**PLANNING DEPARTMENT
DEVELOPMENT AND BUILDING SERVICES
HYDROLOGY DEVELOPMENT SECTION**

Re: Lots 7B and 8 Grande Heights Addition, Grading and Drainage Plan
Engineer's Stamp date 9-17-09 (G11/D068)

**Re: Lots 7B and 8 Grande Heights Addition, Grading and Drainage Plan
Engineer's Stamp date 12-22-09 (G11/D068)**

RE: **Lots 7A & 7B Vista Grande Addition** File: G11-D 068
Drainage Report & Plan for Platting, Grading & paving PE Stamp 11-03-08

DETAILS
SHEET
C5
WAID, WARD CT.

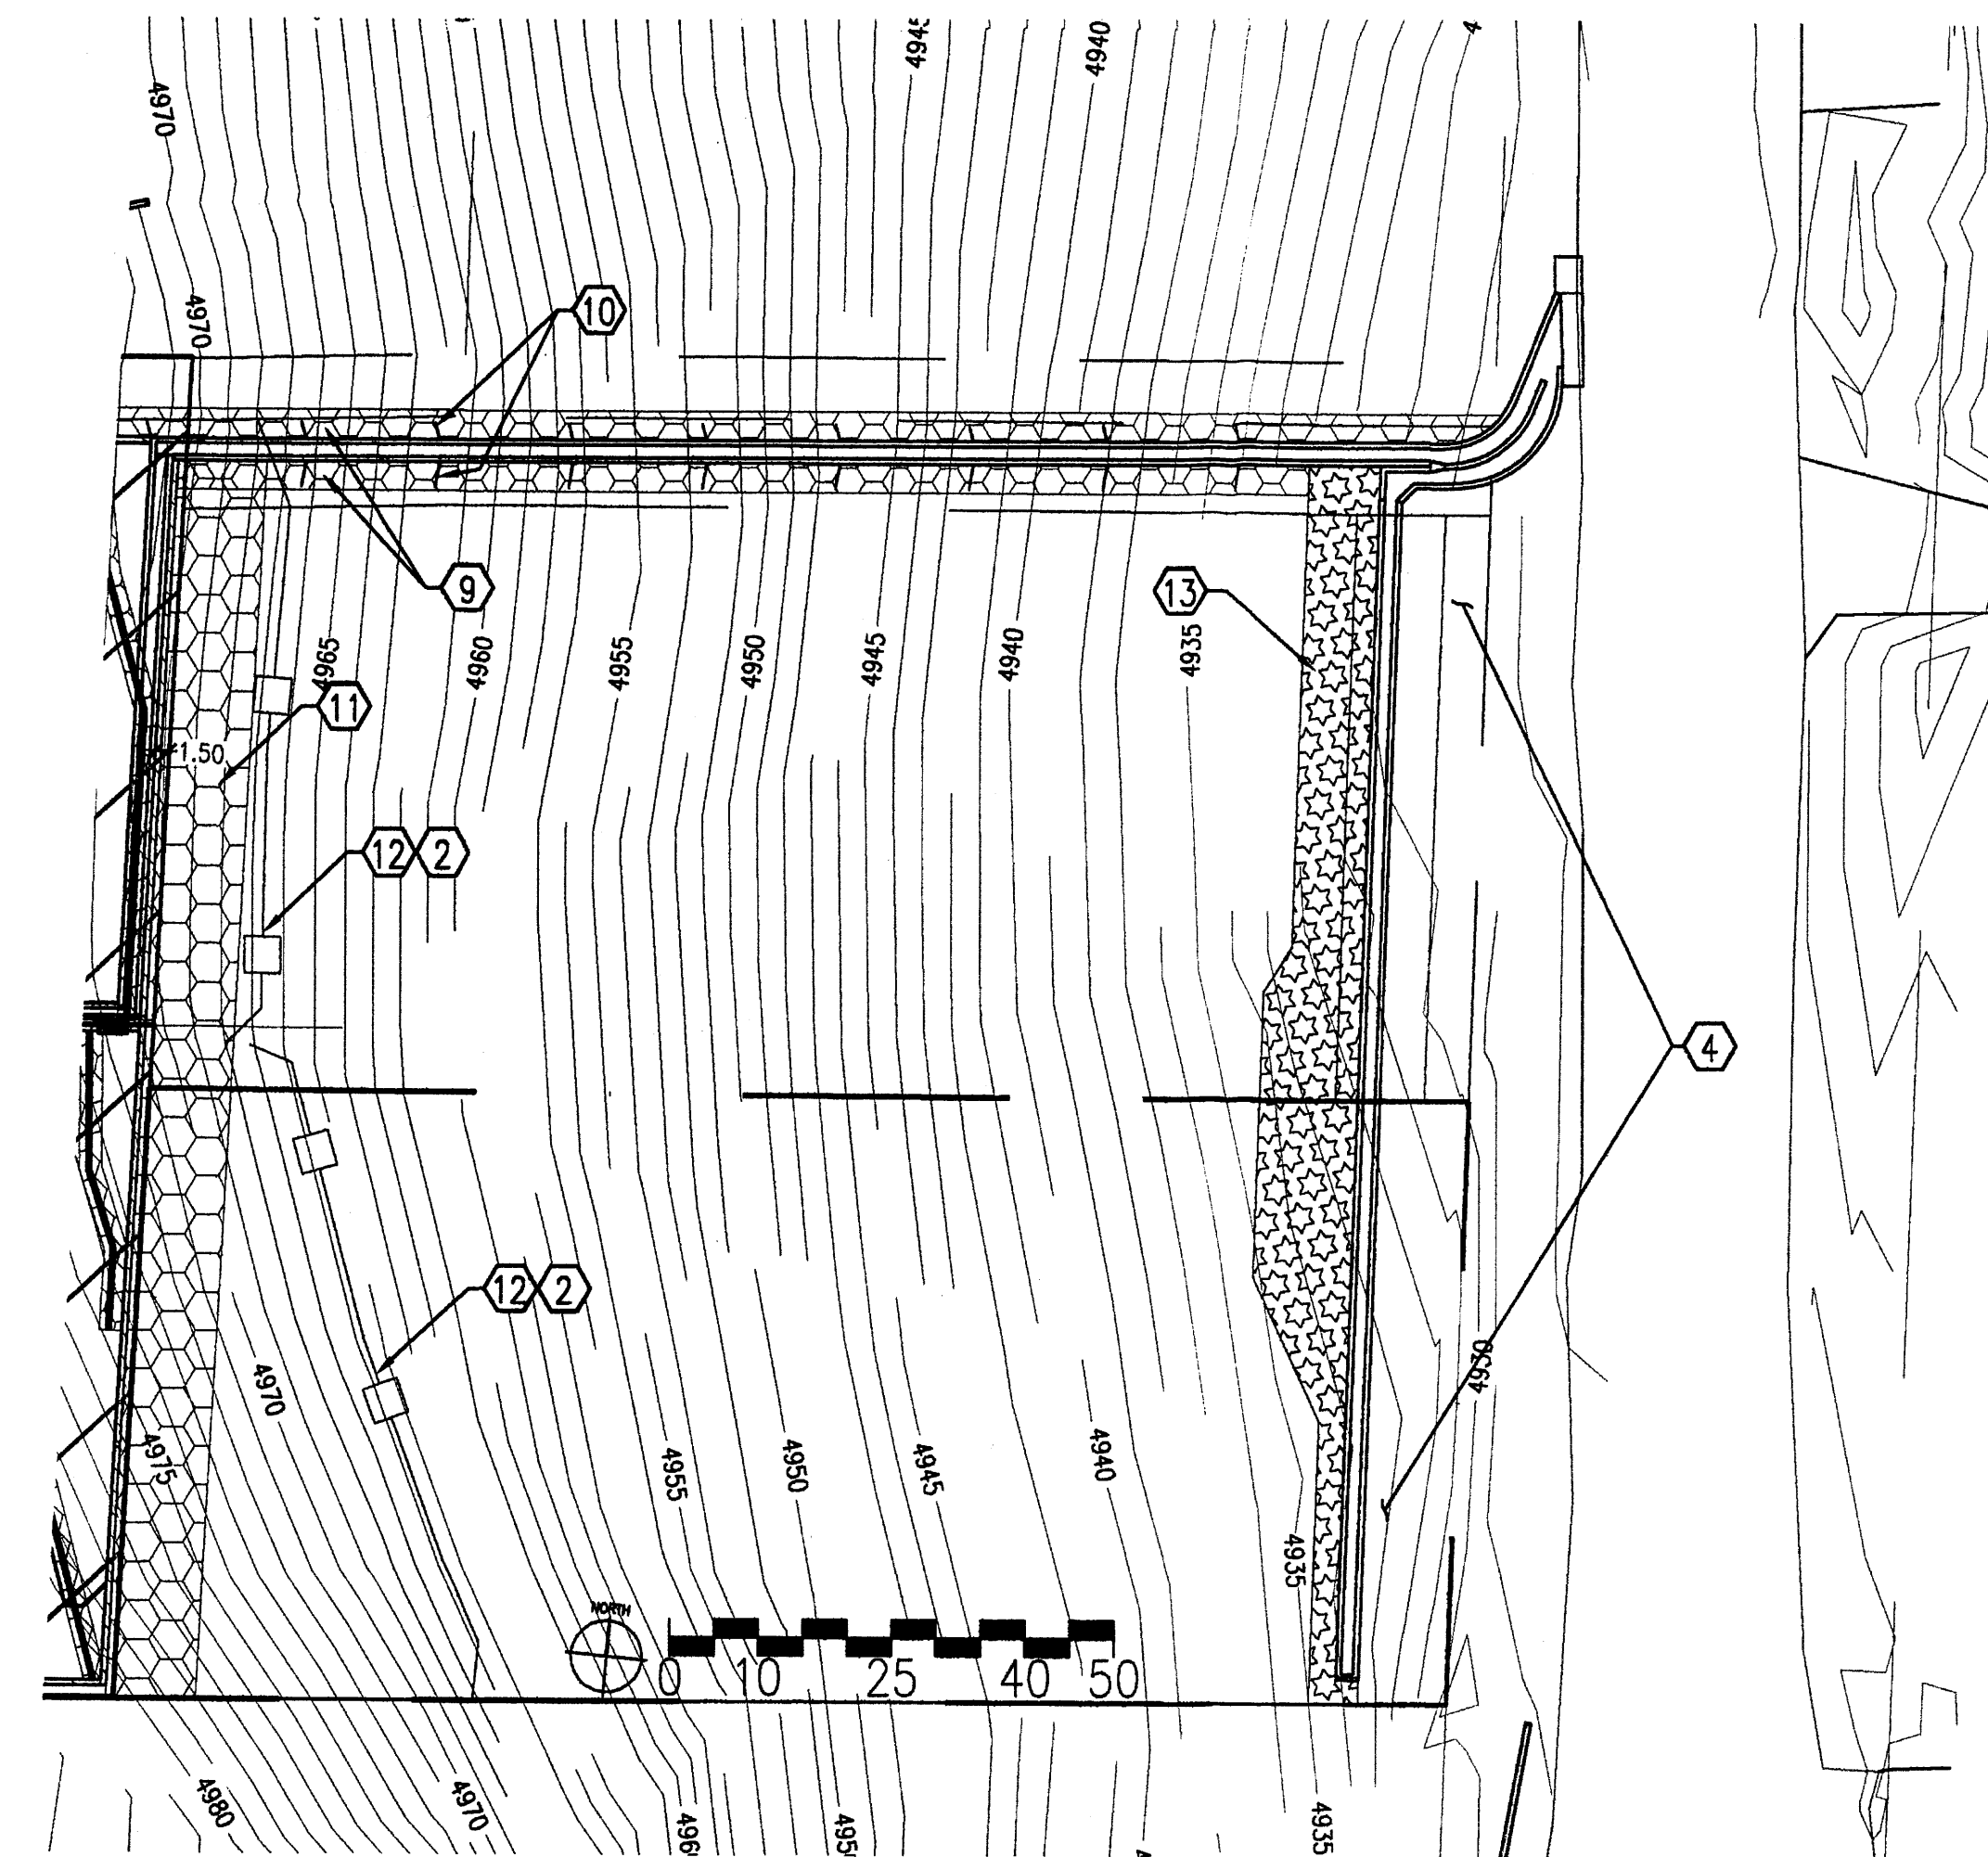
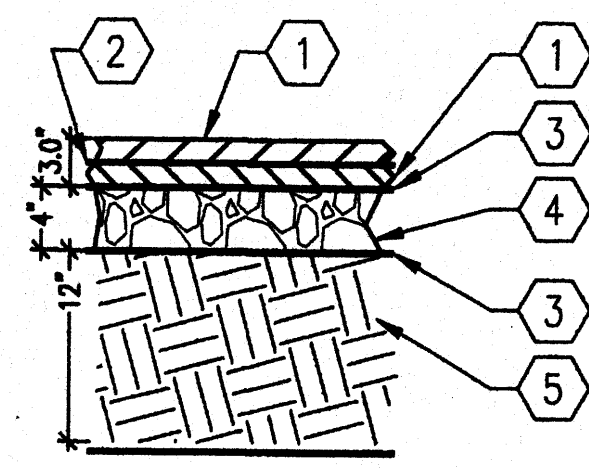
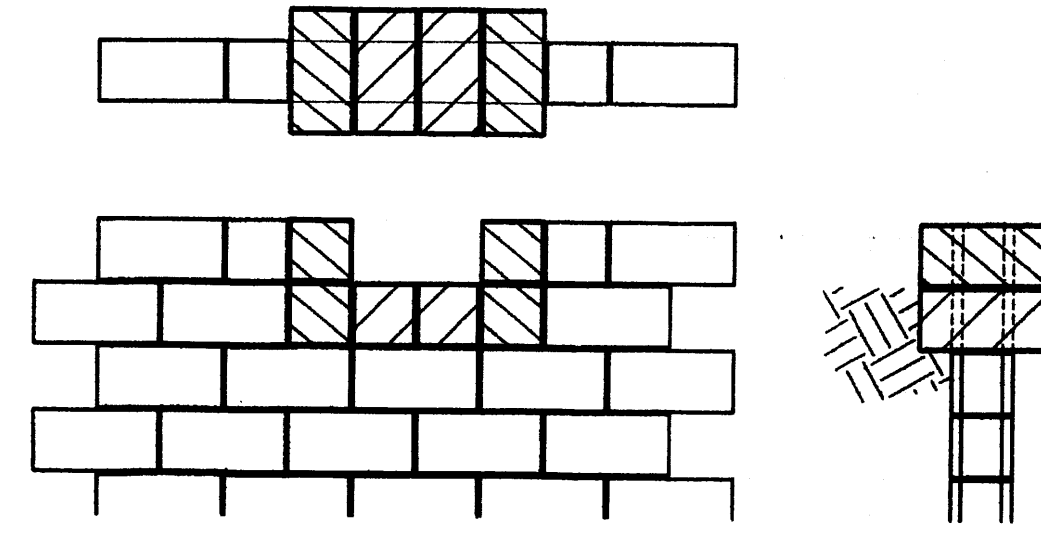
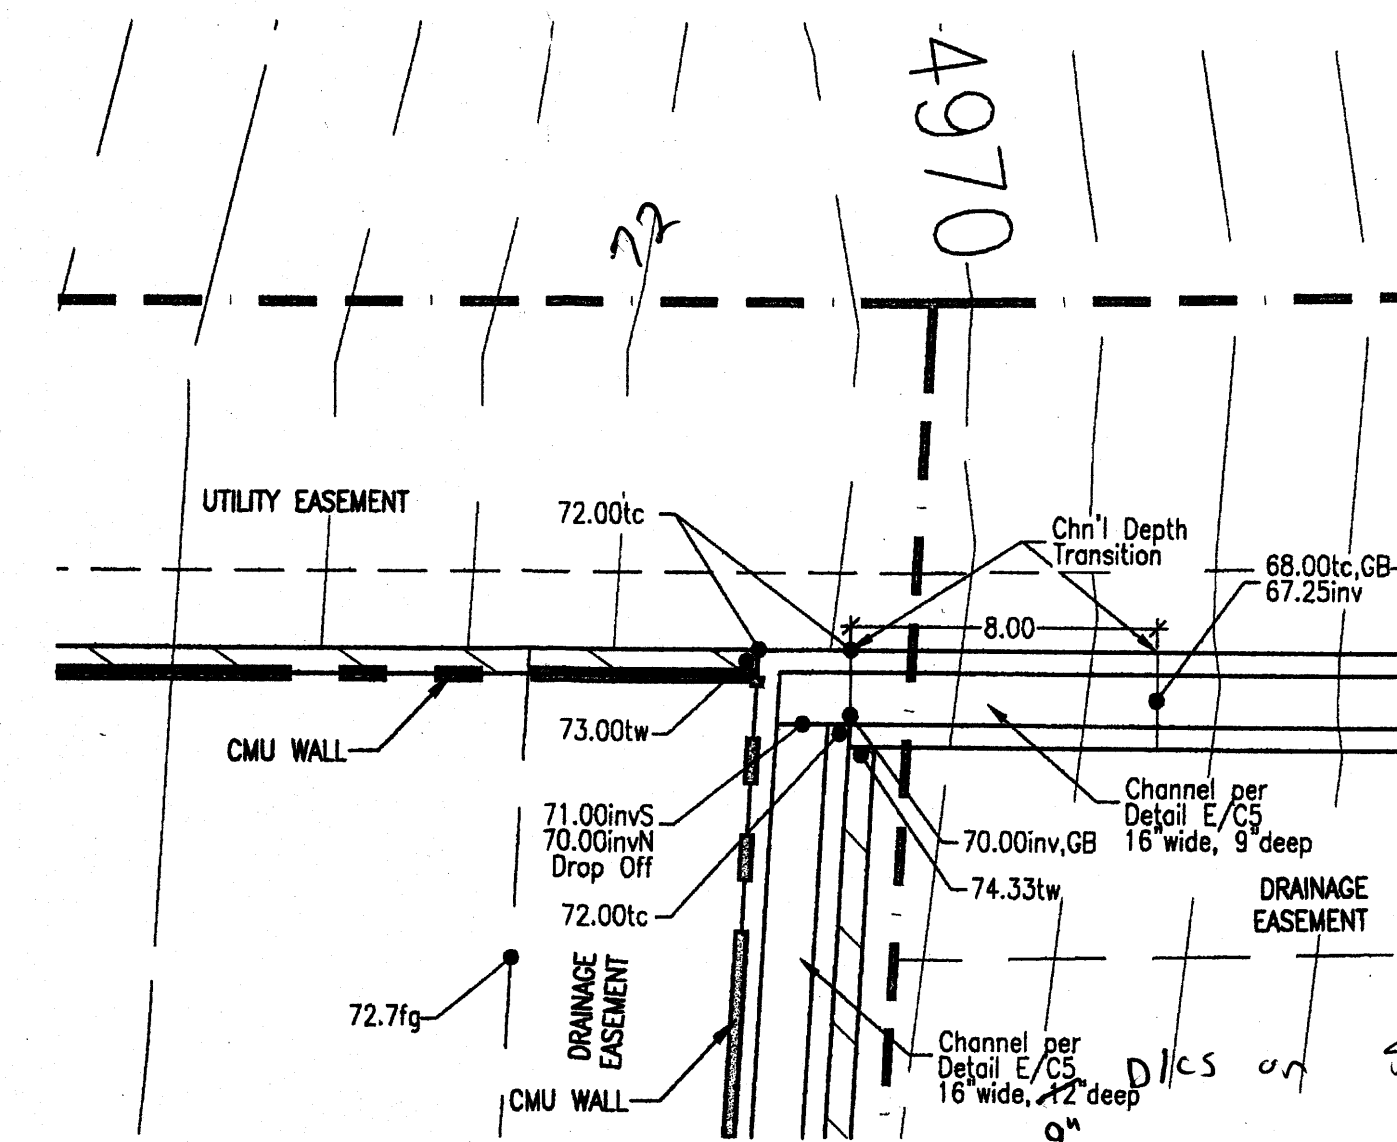
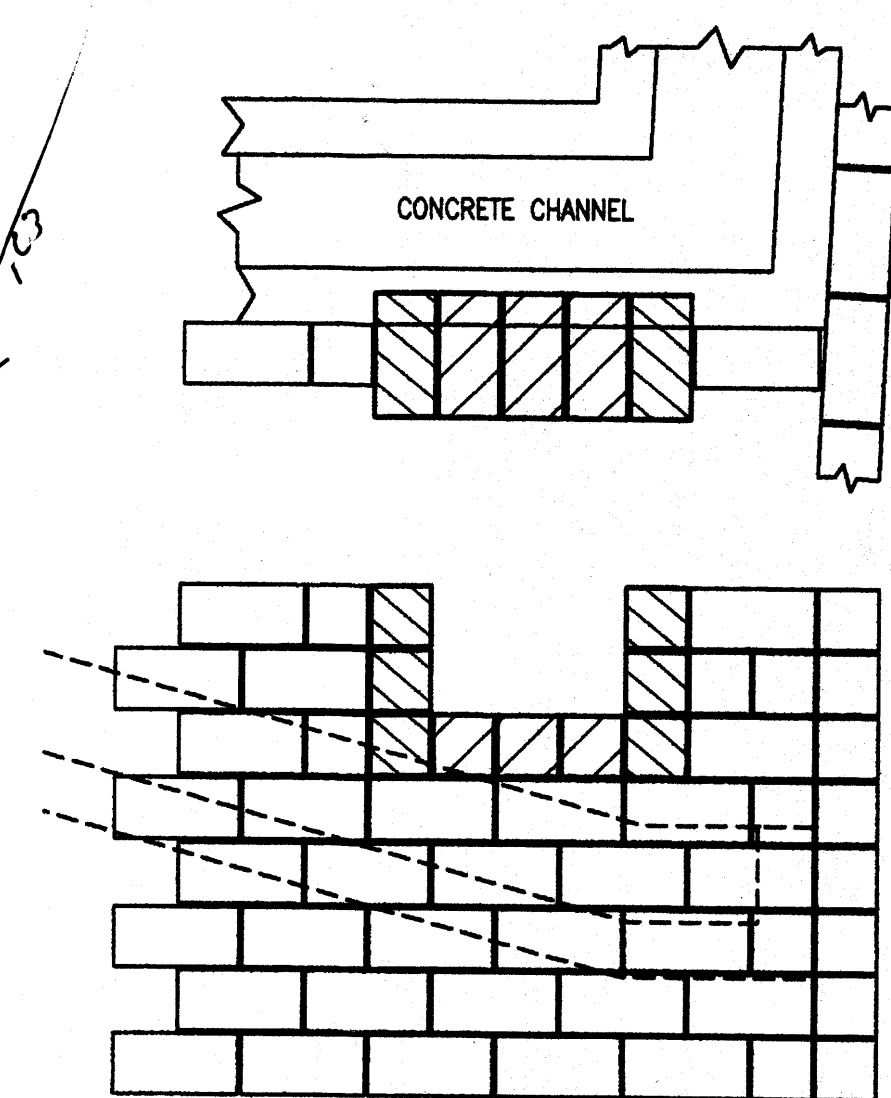
- Rather than stating the slope is greater than 20% (Sheet 7), provide the approximate/average slope.
- The soil underneath the channels should be compacted.
- Provide a scale on Sheet C3.
- On Detail G/D5 one of the channels is referenced incorrectly (E5 rather than D5).

- What is to prevent sediment from entering the north-south channel on Lot 7D?
- Detail B5 depicts the rundown is 19 inches high, yet there is about 7 feet of grade difference. It would also be beneficial to show the entire construction of this rundown in one detail rather than referencing Detail I/C5.
- Detail G/C5 specifies that the north-south channel is per Detail E/C5, while Sheet C2 specifies Detail D/C5 for the same channel.
